Applicant: L & Q Estates

Proposal: Discharge of condition 50 (earthworks) of 14/01932/OUT

DATE: 15 March 2021

HYDROCK PROJECT NO.	SCALE @ A/D	STATUS
C-04841-C	AS SHOWN	S2
INFORMATION		
DRAWING NO. (PROJECT CODE-ORIGINATOR-ZONE LEVEL-TYPE-ROLE-NUMBER)		
WPF-HYD-XX-XX-DR-C-0210		P03

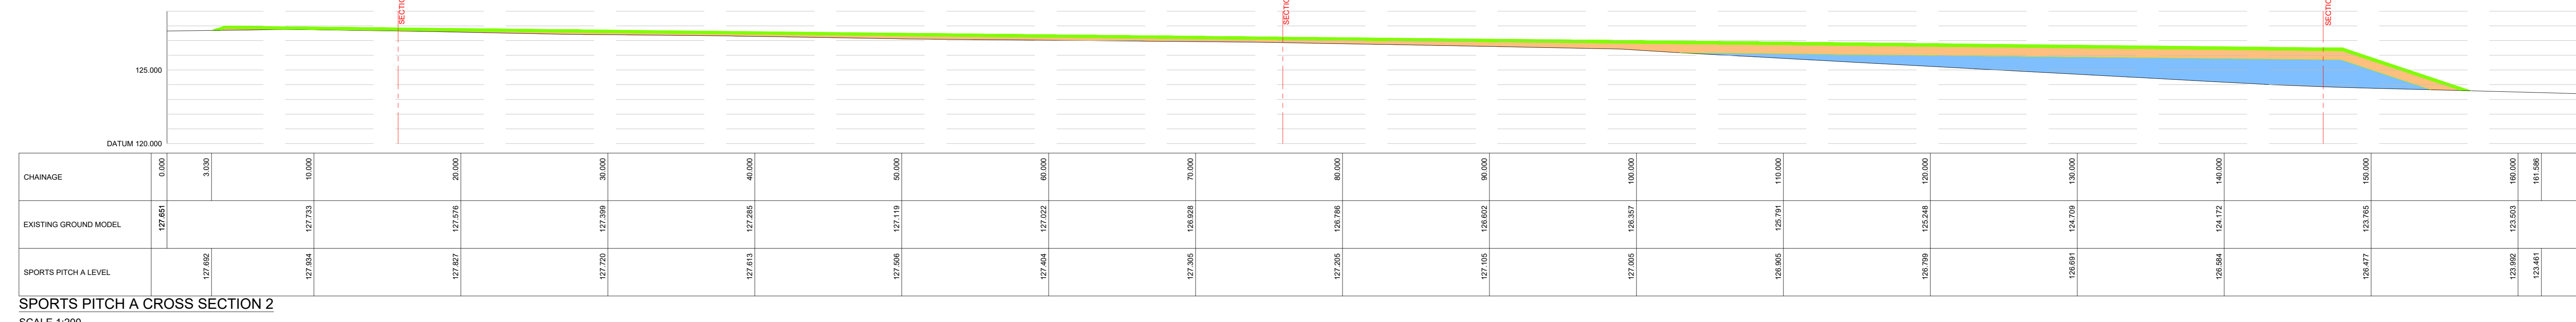
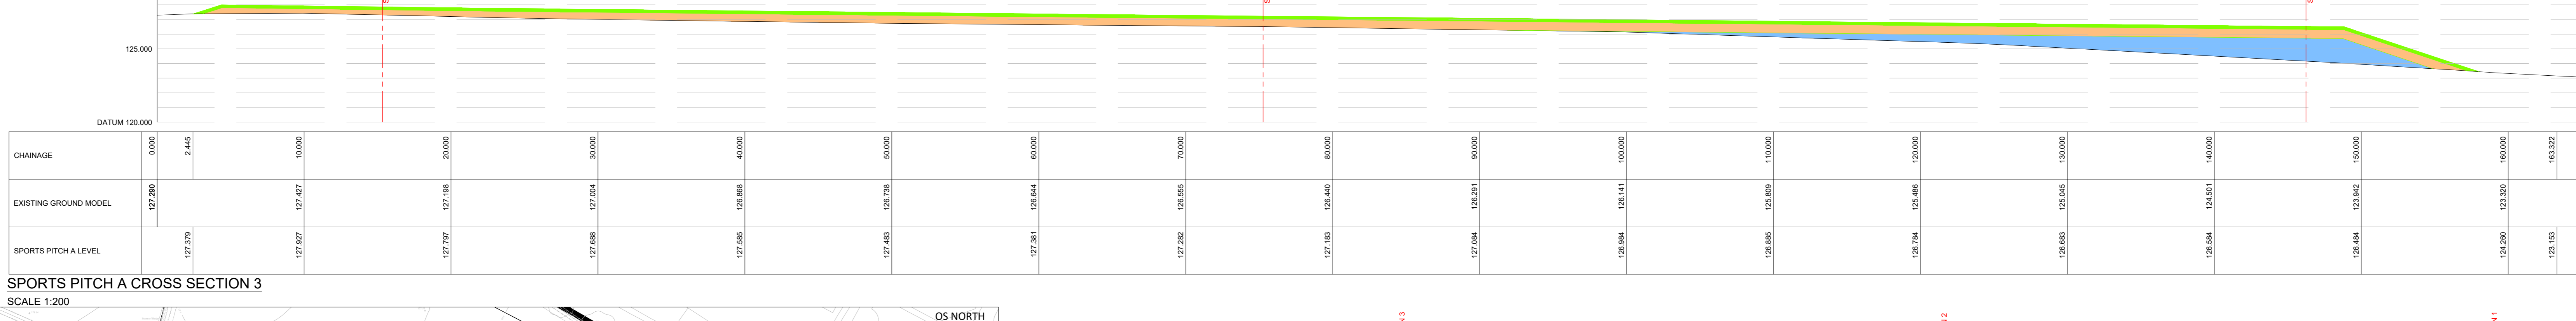
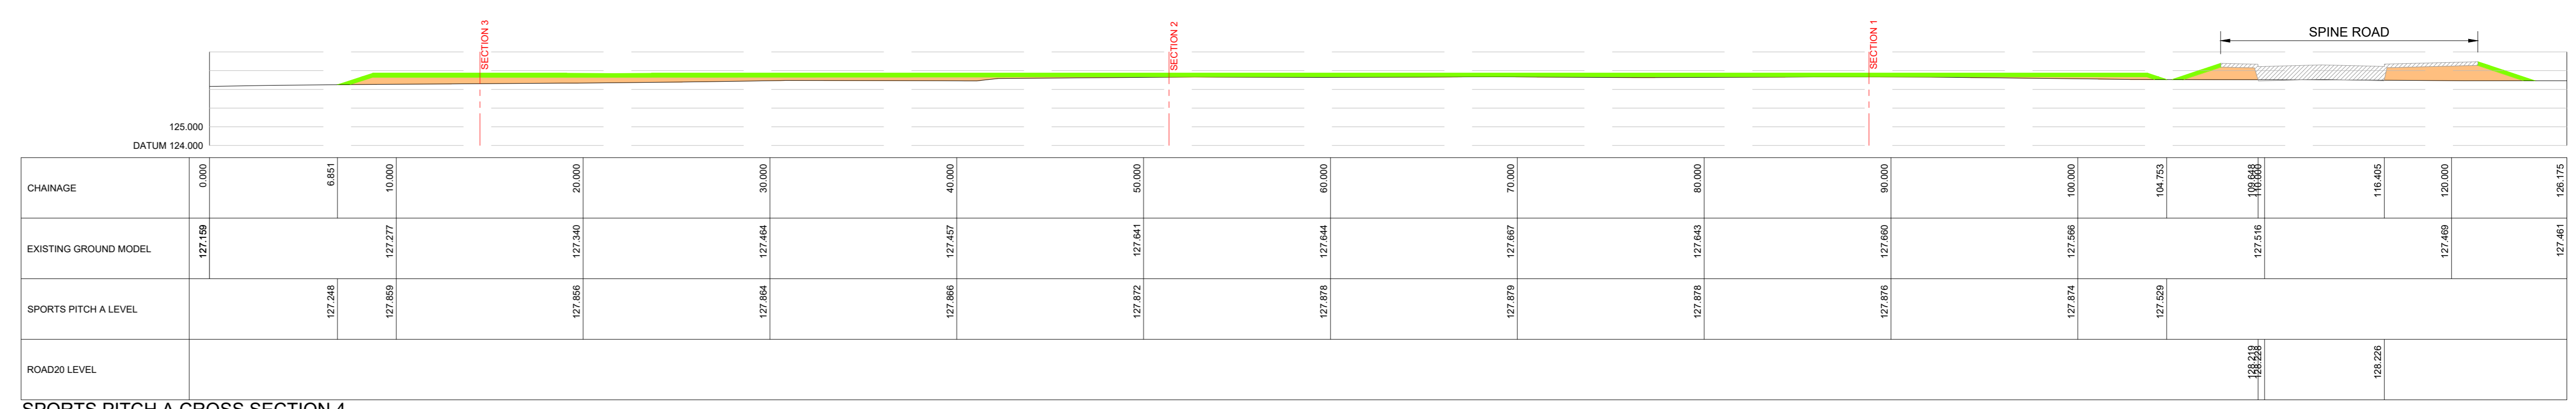
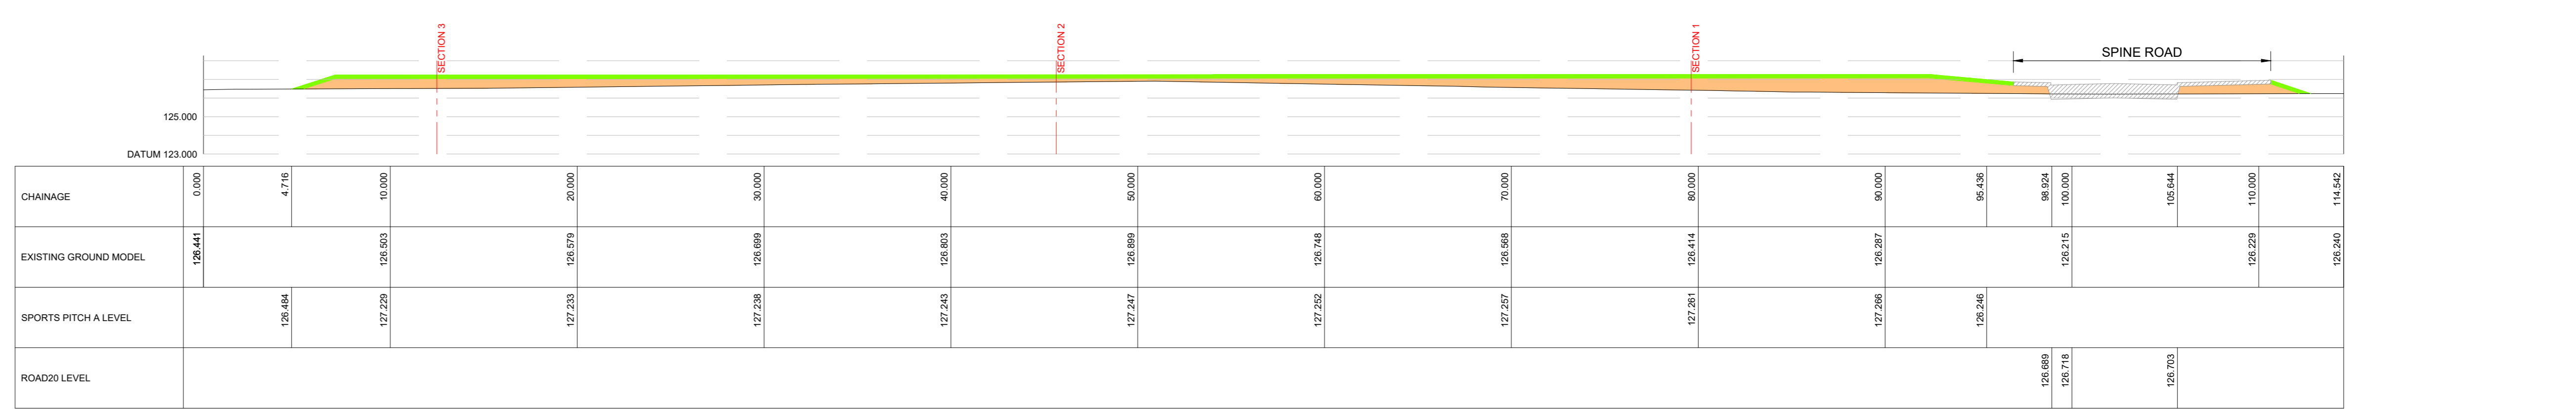
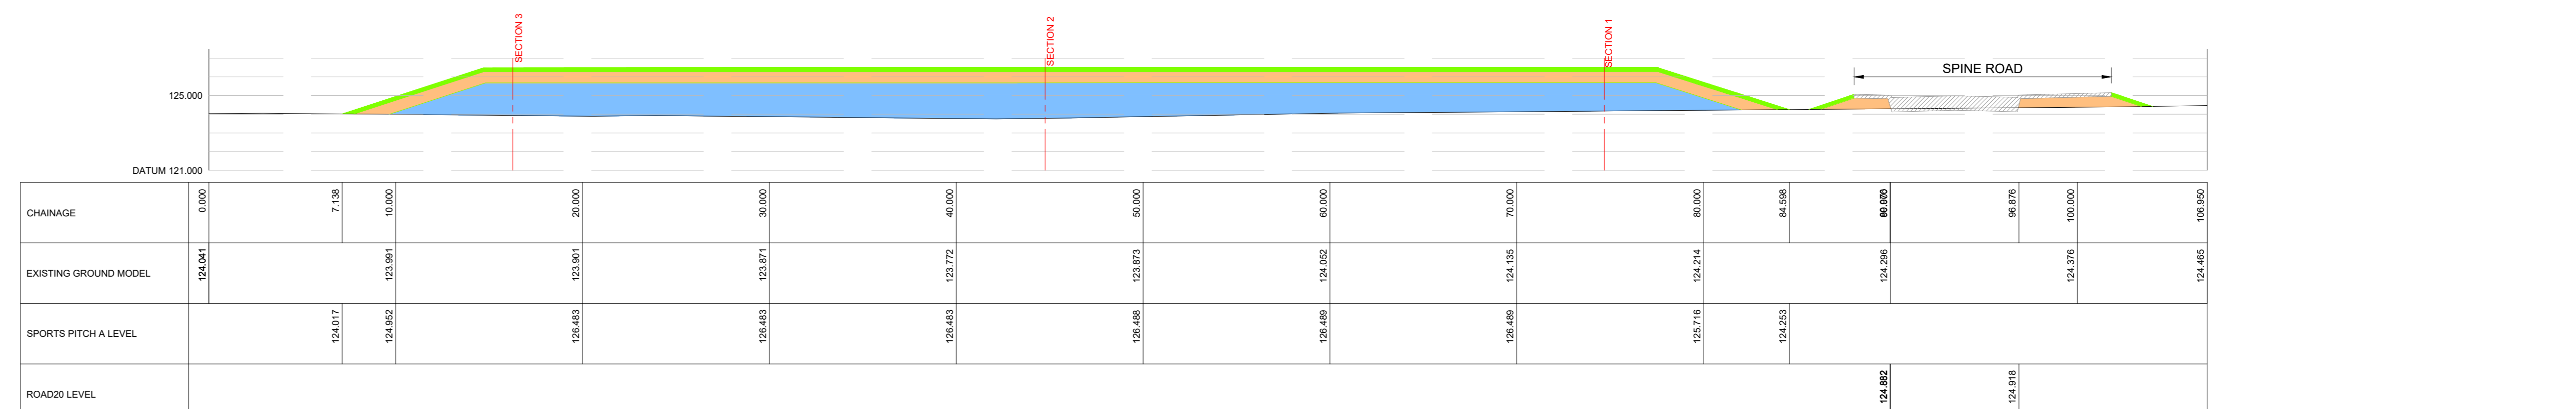
4.3 CDC Landscape: Some concerns about the depth of the basins to be created and the east side of the football pitch is quite steep. How will the mound relate to the play area at the gateway?

- 5.3 Some concern was raised by the Landscape Officer regarding the depth of the basins, their steep side profiles and the steep sides to the sports pitches. These matters have been discussed further with the applicant and agent. The basins will be designed to RoSPA standards and the edges are to be defined through planting and landscape treatment.

- 5.4 All batter slopes have been designed at 1:3 side slopes, including the slope to the east of the football pitch. It is not possible to extend the base of the batter without compromising the easement to the trunk water main and to slacken the batter would compromise the size of the pitches which have been specified through the Section 106 agreement. The plateau upon which the sports pitches are proposed is necessary to protect important archaeological remains below.
